**From:** Taylor Gustafson  
**Sent:** Thursday, August 01, 2019 8:48 AM  
**To:** Kelly Bacon; Lindsey Ozbolt  
**Subject:** FW: VA-19-00001 Berlin Setback Variance  
**Attachments:** SKM\_C654e19072212410.pdf

**From:** Justin Turnbull  
**Sent:** Monday, July 22, 2019 12:26 PM  
**To:** Taylor Gustafson  
**Subject:** RE: VA-19-00001 Berlin Setback Variance

**Subject:** VA-19-00001 Berlin Setback Variance

Sheet Name:
Site Plan

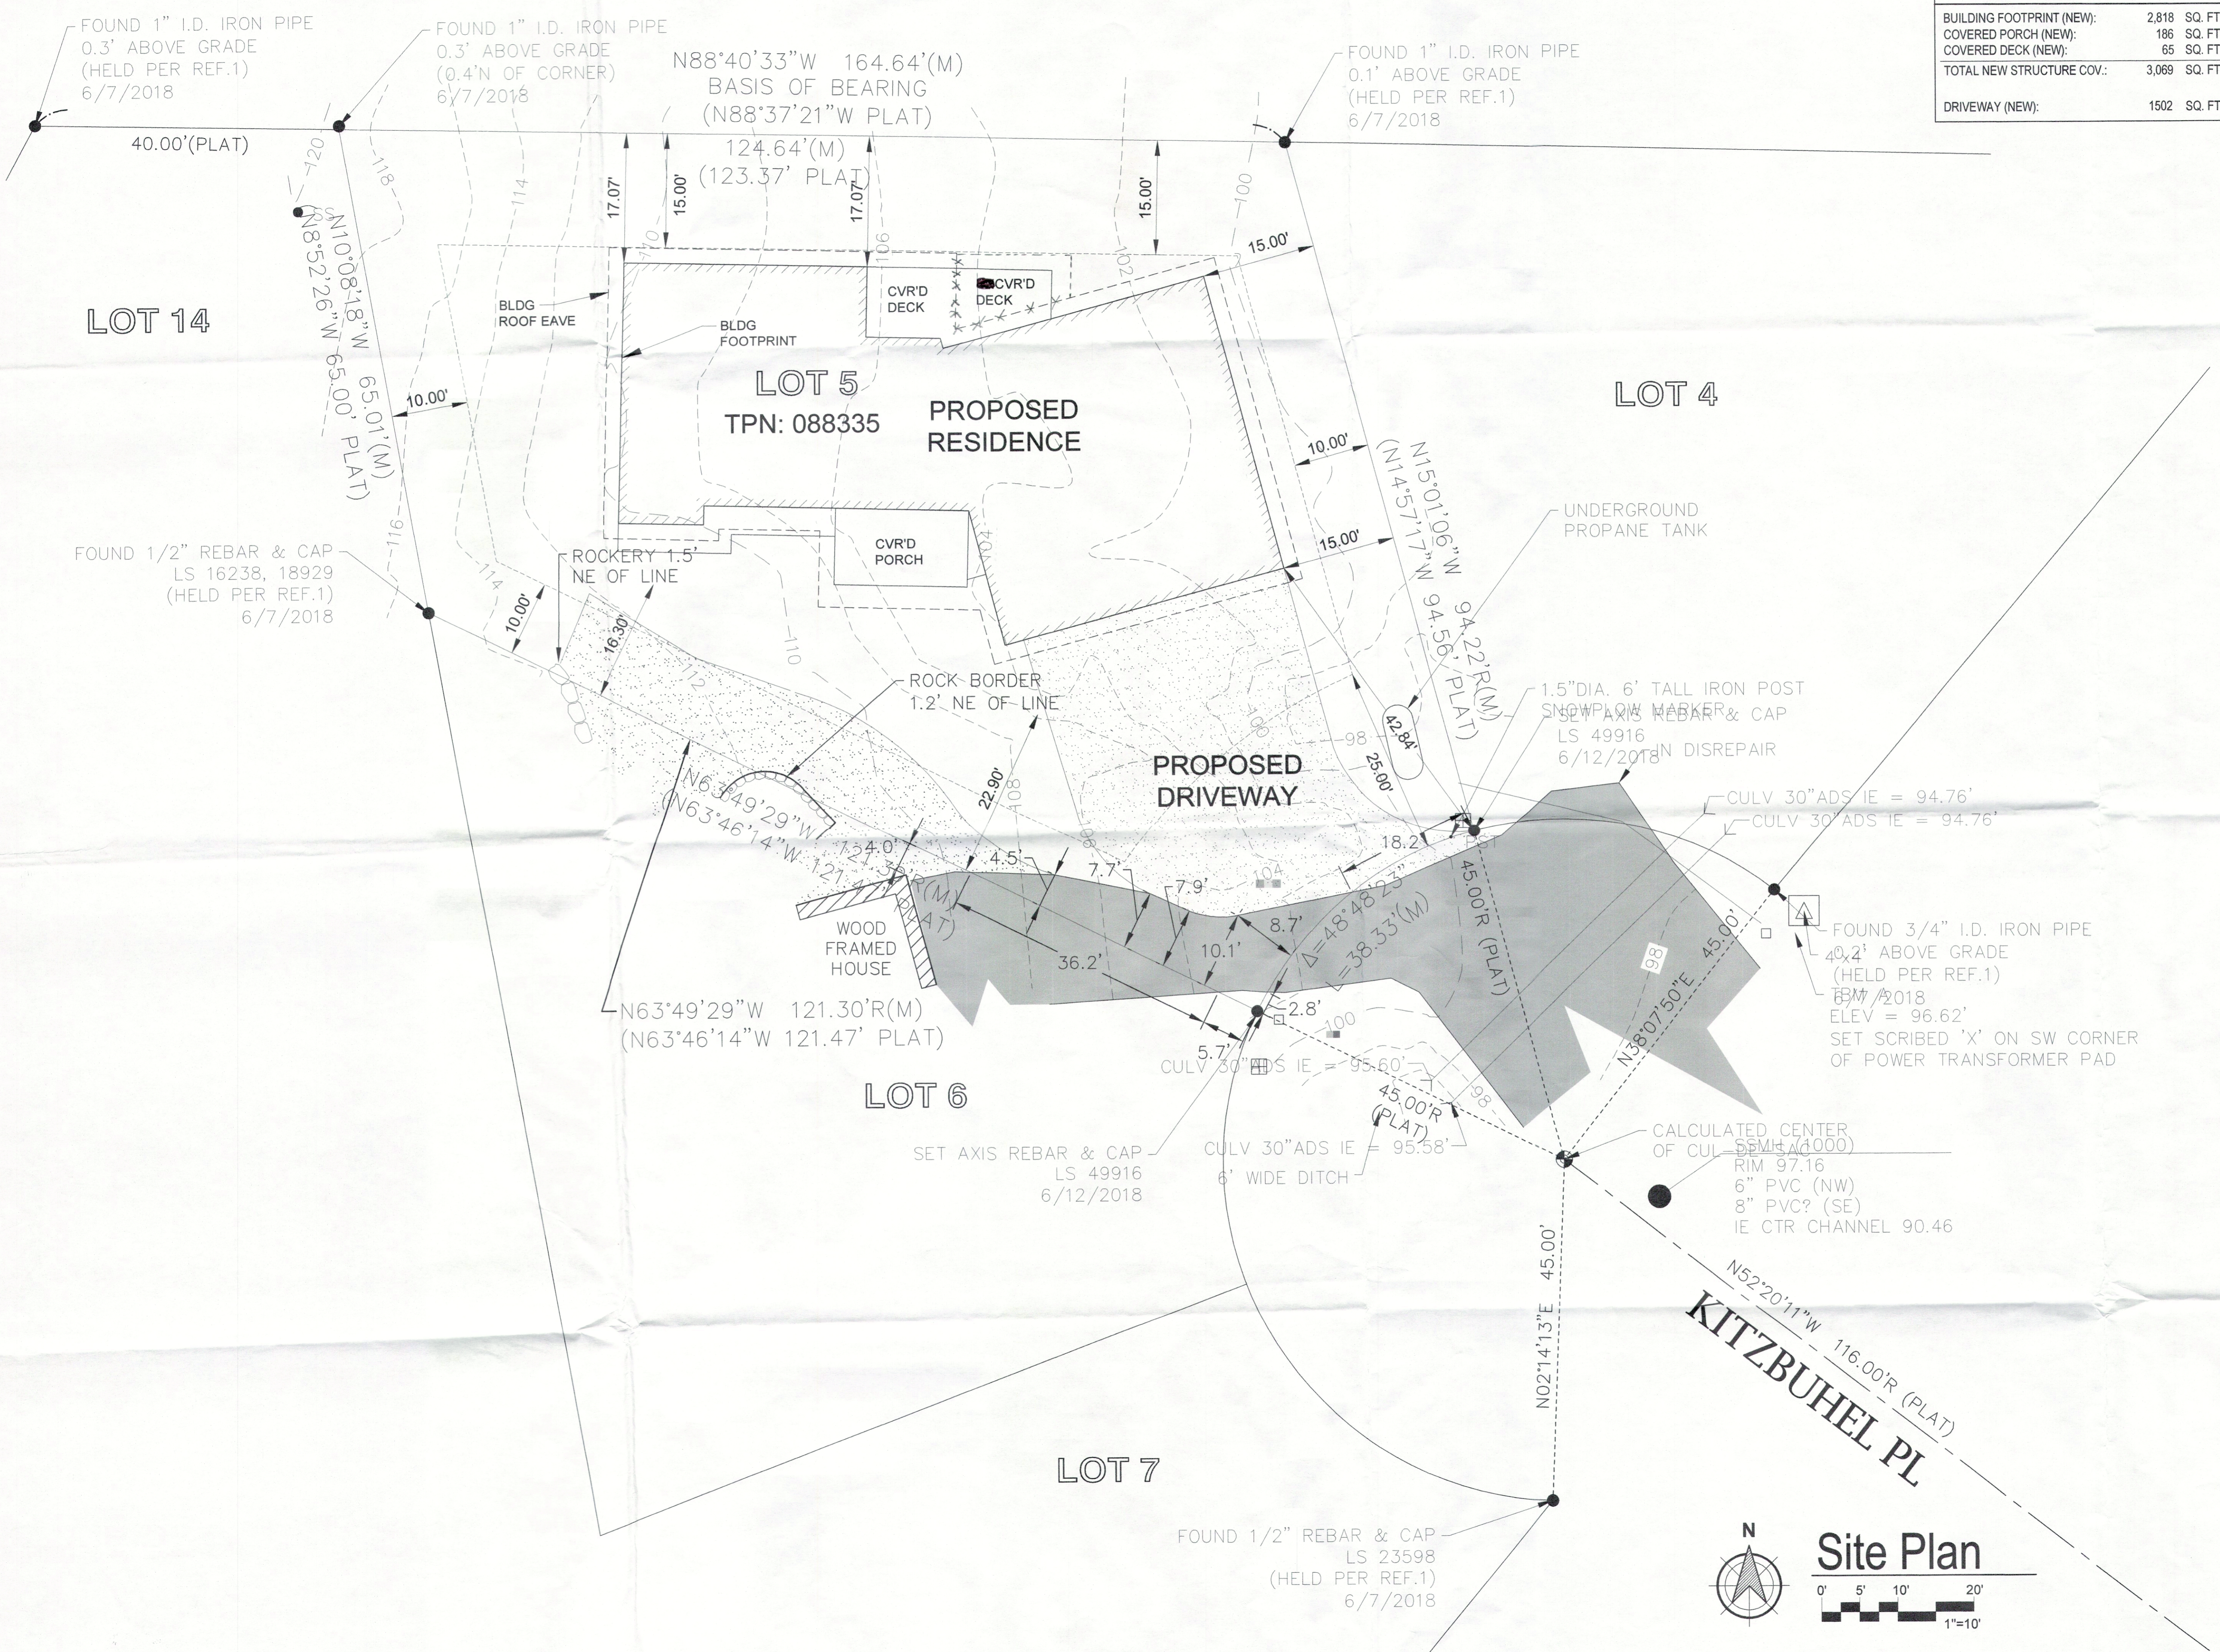
The documents on the server have not been prepared by a surveyor per Dusty Pilkington's request. From the information I can glean from the site plan, it appears that a surveyor was involved (AXIS – PLS#49916), but this is not their original work.

I would also be prudent to have the applicant confirm that the utility lines located at the back of the subject parcel do not have an easement they will be encroaching upon. Their surveyor should be able to confirm this from their title report.

While not relevant to survey, the existing footprint CAN fit on the existing lot holding to the existing setbacks. Please see attached sketch.
